City of Portland, Maine - Building or Use Permit Application

Job No: 2011-08-1835-SF	Date Applied: 8/1/2011	CBL: 402 - - D - 003 - 001 - - - - -	
Location of Construction: 58 GERTRUDE AVE	Owner Name: Diversified Properties	Owner Address: PO BOX 10127 PORTLAND, ME - MAINE 04104	Phone: 207-773-4988
Business Name:	Contractor Name: Custom Built Homes, LLC	Contractor Address: 123 Christopher Rd., BNorth Yarmouth, ME 04021	Phone: (207) 650-69898
Lessee/Buyer's Name:	Phone:	Permit Type: Building - New Single Family	Zone: R-3
Past Use: Vacant land	Proposed Use: New Single family - renew permit #10-0901 - build a cape with full dormer - 32' x 24'	Cost of Work: 1000.00	CEO District:
		Fire Dept: <input checked="" type="checkbox"/> Approved w/conditions <input type="checkbox"/> Denied <input type="checkbox"/> N/A	Inspection: Use Group R-3 Type: SB IRC-2009
Proposed Project Description: New Single family home - renew permit #100901 UI		Signature: <i>Capt. Malone 9/22/11</i> Pedestrian Activities District (P.A.D.)

Jonathan Rioux - RE: 58 Gertrude Ave.

From: Jonathan Rioux
To: Jim Wolf
Date: 12/27/2011 10:45 AM
Subject: RE: 58 Gertrude Ave.

SECOND FLOOR PLAN

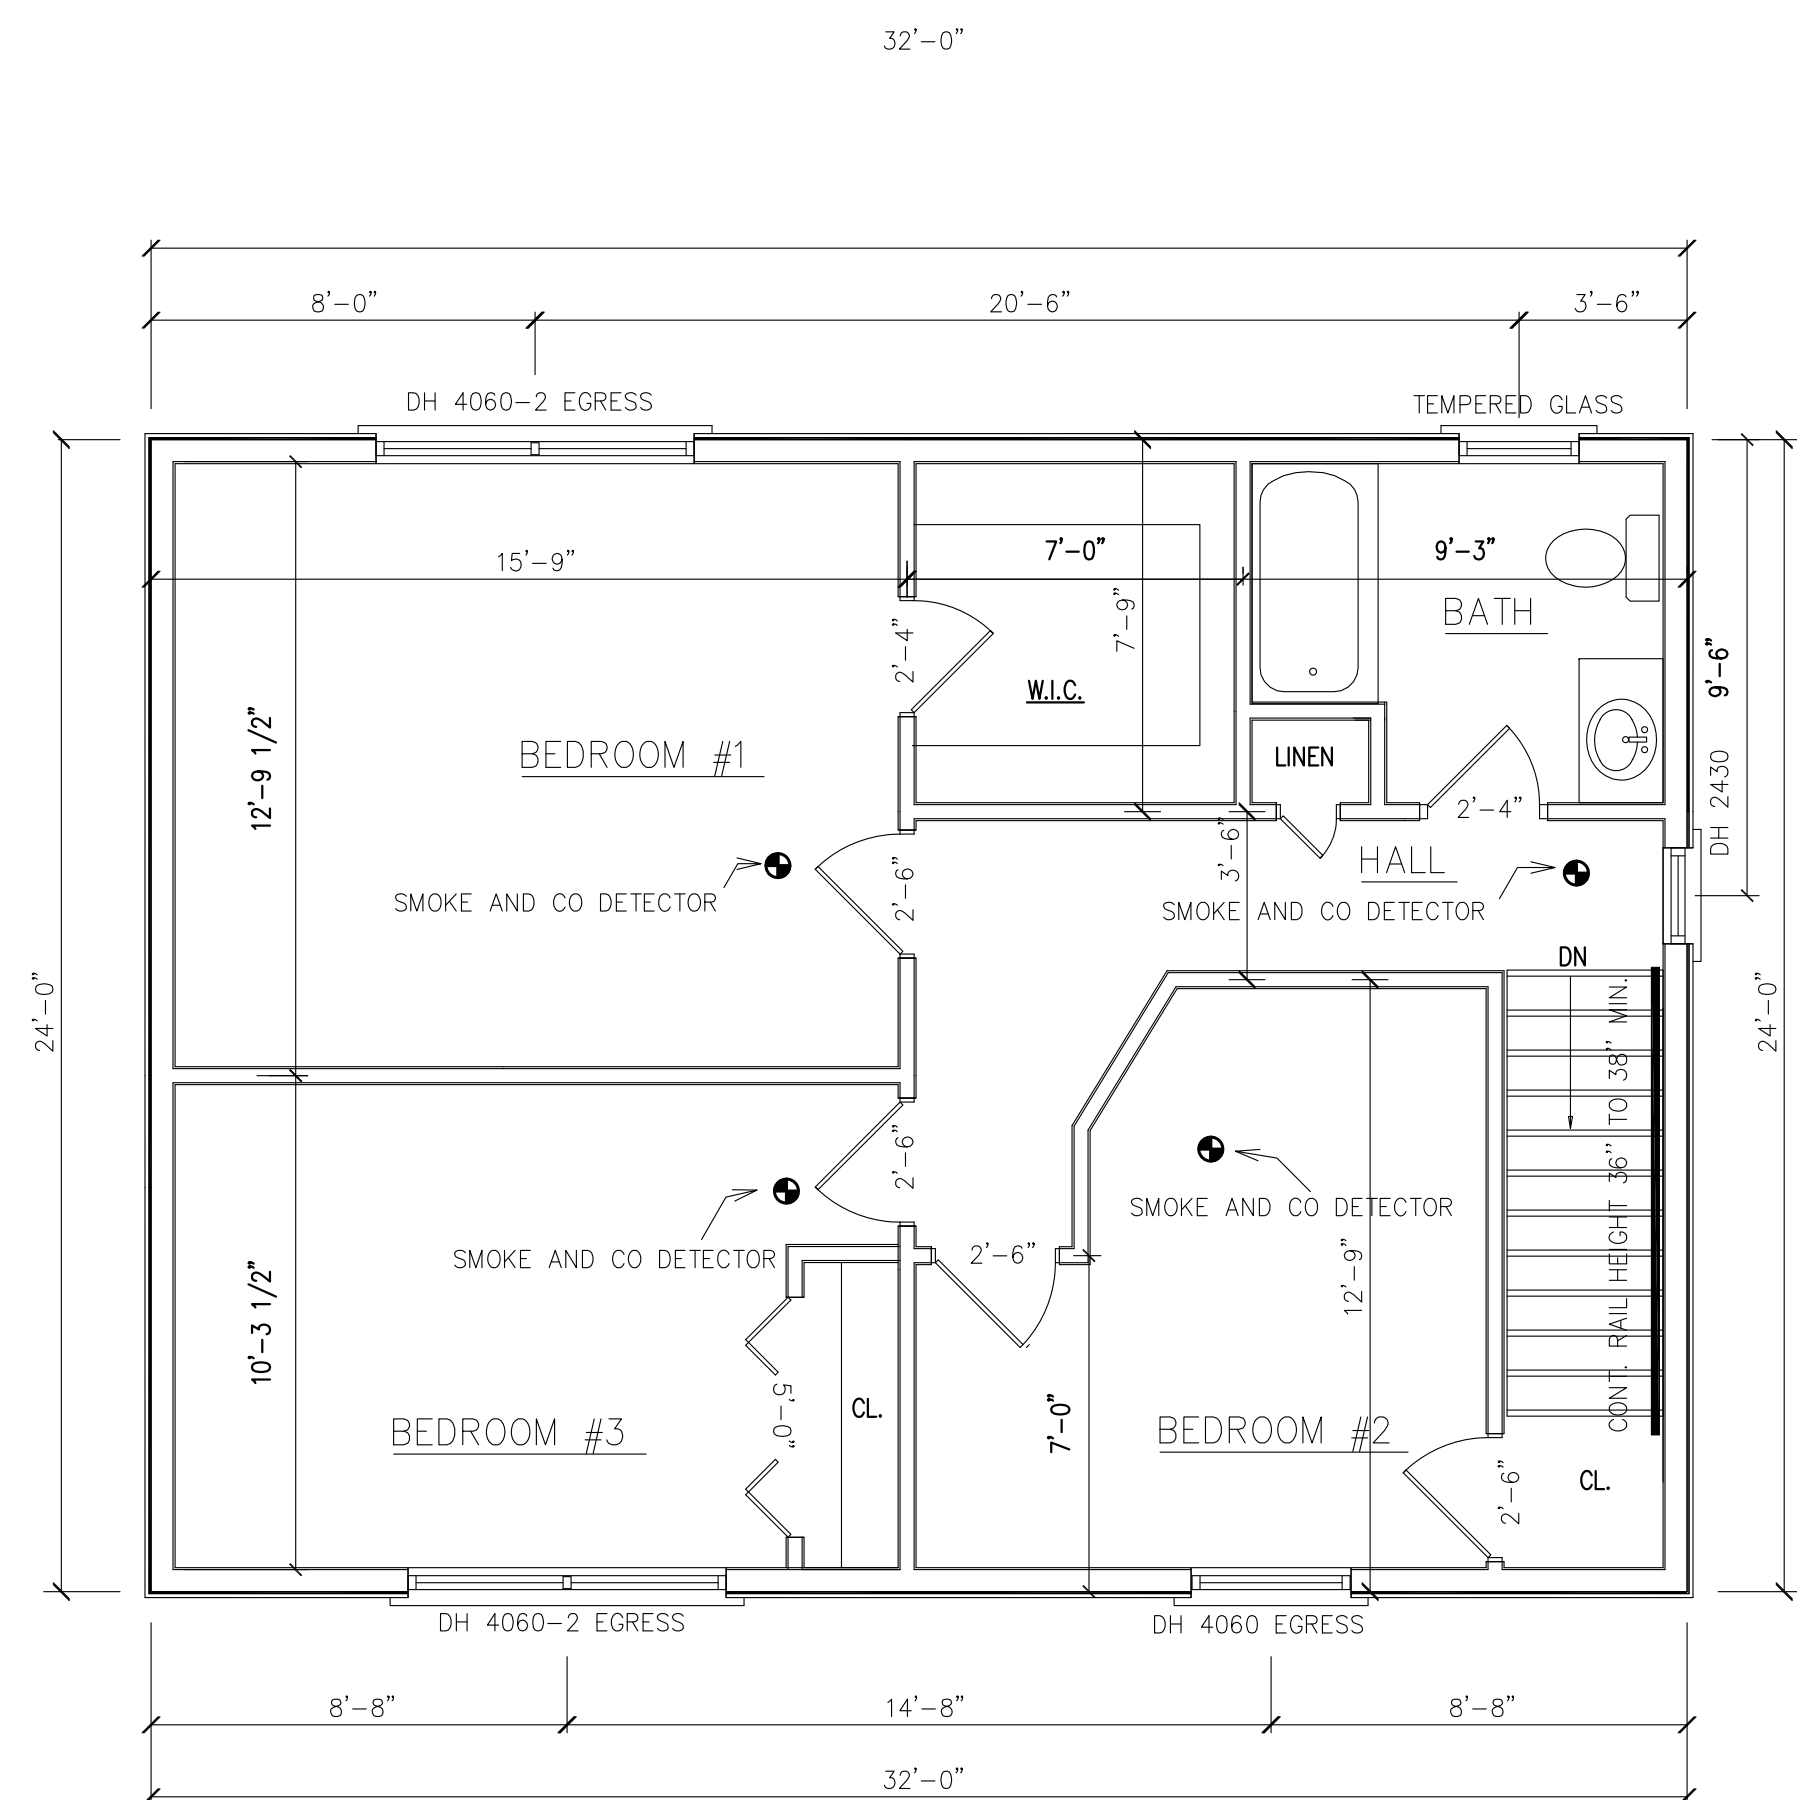
- A Cross Section of the Second Floor Framing/ Girder(s) in Compliance with (Table R502.5(1))
- Building Envelope Energy requirements must comply with MUBEC
- The Fastener Schedule shall be MUBEC (IRC, 2009)
- Ventilation of this space is required per ASRAE 62.2 , 2007 edition

SECTION THRU HOUSE
 SCALE : 1/4" = 1' - 0"

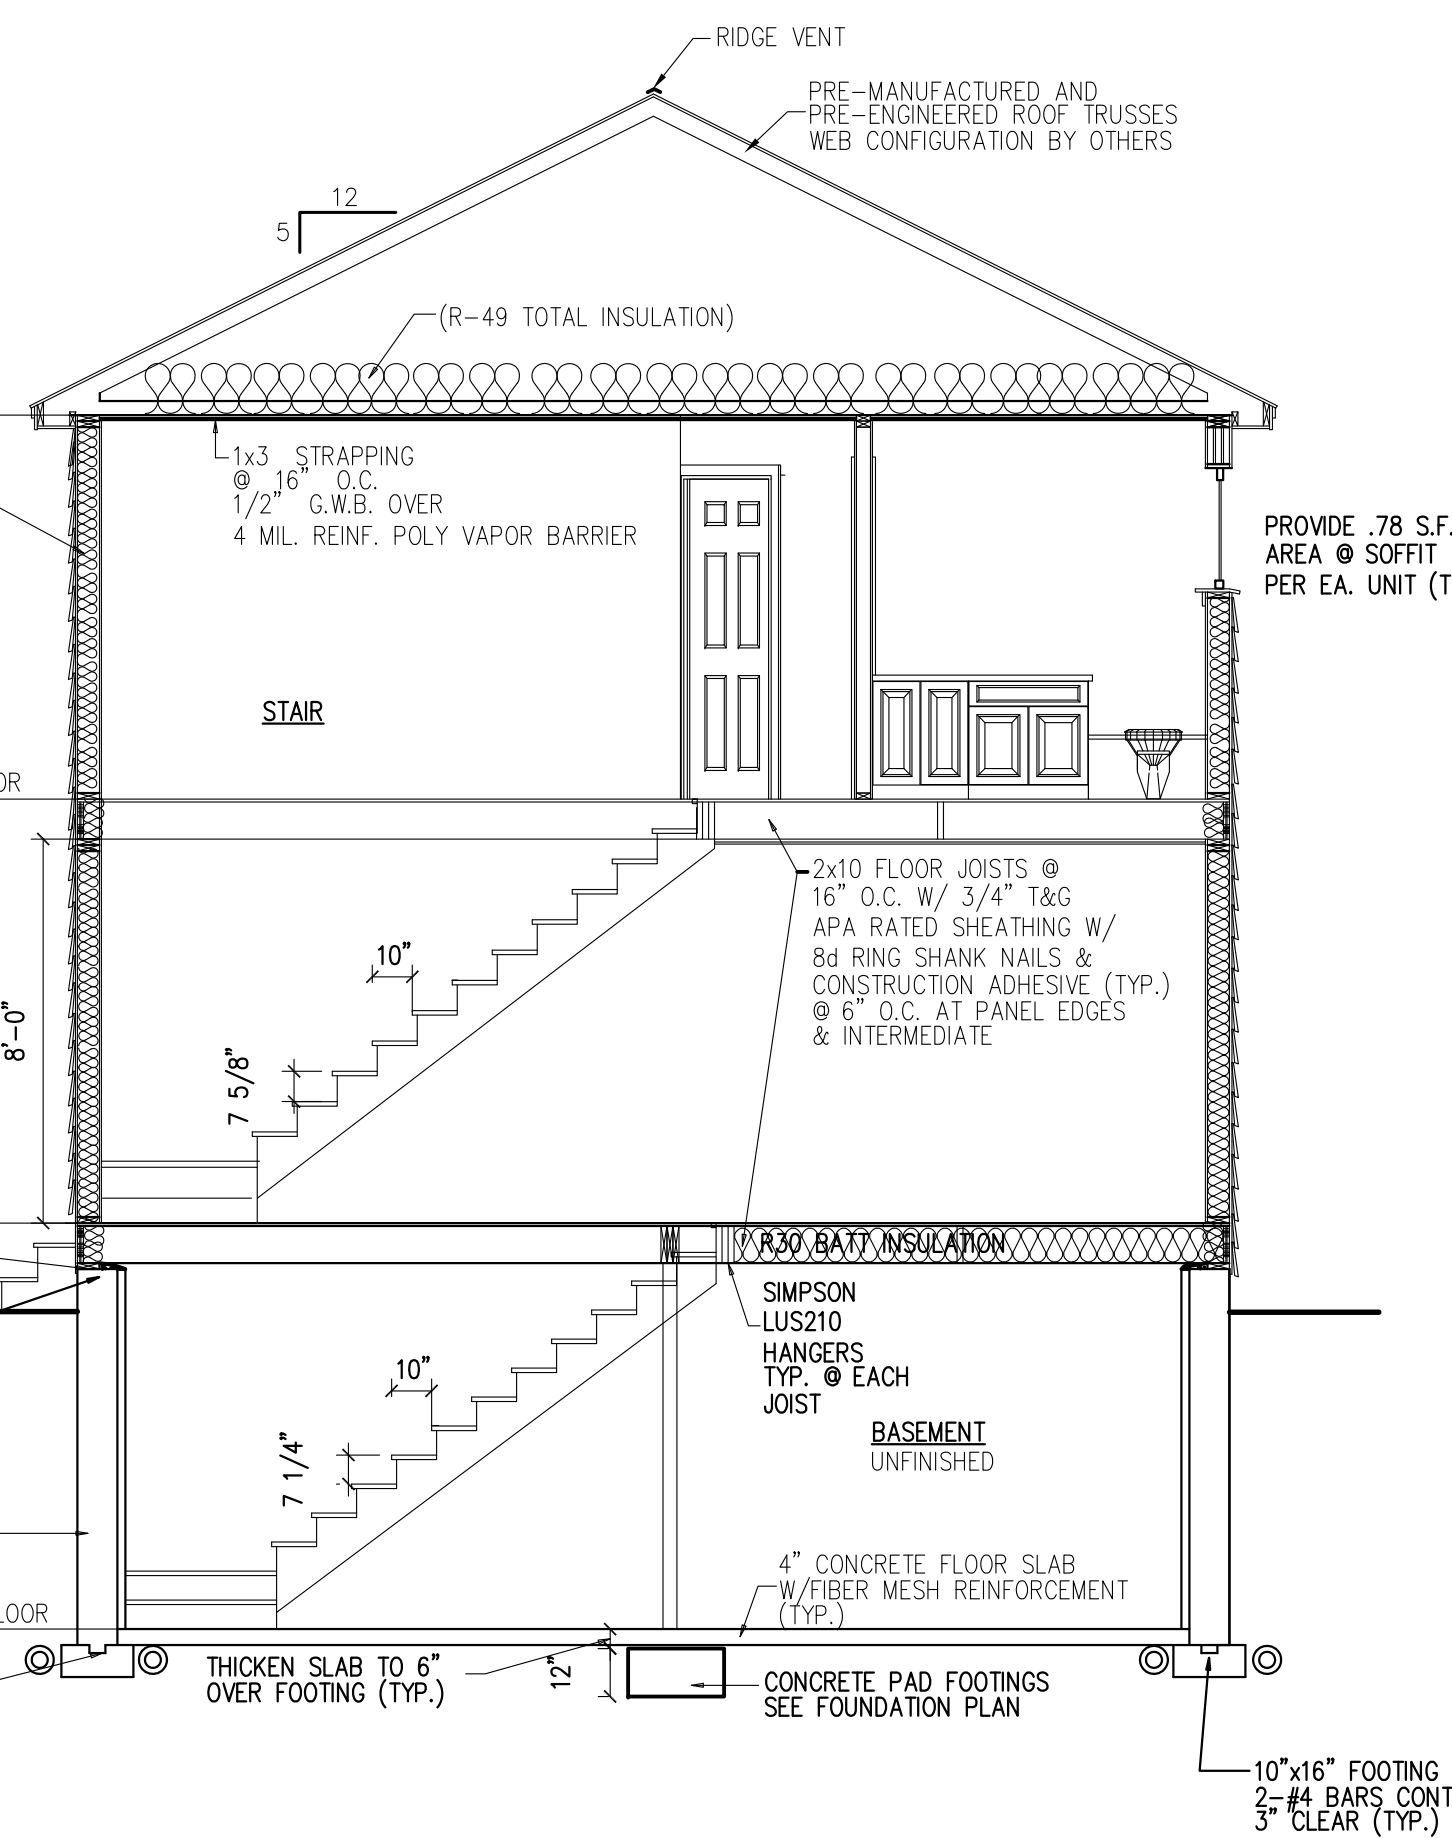
Basements, habitable attics and every sleeping room shall have at least one operable emergency escape and rescue opening. Habitable Attics: A finished or unfinished area, not considered a story, complying with all of the following requirements:

- 1. The occupiable floor area is at least 70 square feet, in accordance with Section R304,*
- 2. The occupiable floor area has a ceiling height in accordance with Section R305, and*
- 3. The occupiable space is enclosed by the roof assembly above, knee walls (if applicable) on the sides and the floor-ceiling assembly below.*

Window sills in locations more than 72 inches from finished grade shall be a minimum of 24 inches above the finished floor of the room, unless a window fall prevention devices is installed in accordance with section R612.3.

A code compliant emergency escape shall be provided in the bedroom. Window sills in locations more than 72 inches from finished grade shall be a minimum of 24 inches (no higher than 44 inches) above the finished floor of the room, or in compliance with Section R612.4.2 Operation for emergency escape.
